Subject: RE: Planning Consultation on: BR/109/20/PL

Application No: BR/109/20/PL

Site Address: The William Hardwicke 12 12 High Street Bognor Regis PO21 1SR

Description of Works: Change of use of part of the existing car park to pub garden, erection of 4 no. semi enclosed covered seating huts, addition of servery to form external bar and reduce height of existing shelter by 0.6m and associated works.

D500 PROPOSED HUTS
Scale: 1:50

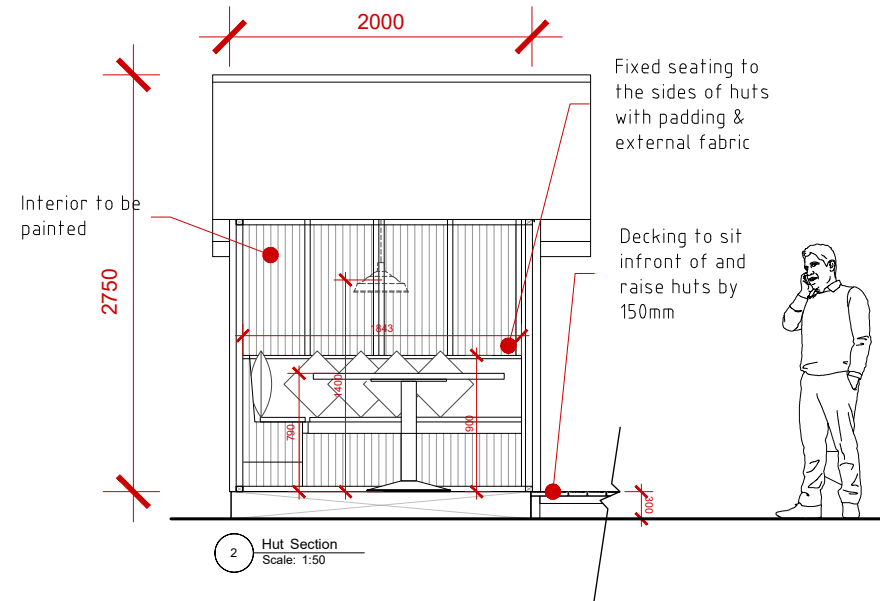
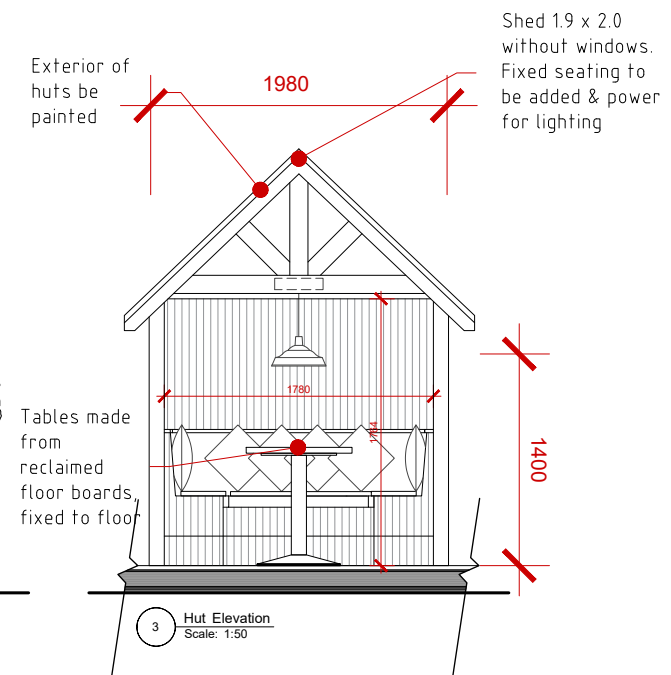
5. In principle I accept the proposal for the northern boundary fence but would suggest that acoustic properties to the boundary are considered in light of the residential properties close to this site.
6. It also important to remind the agent that the smoking shelter in the proposed extended beer garden is not substantially enclosed and that no smoking is carried out in the wooden huts.
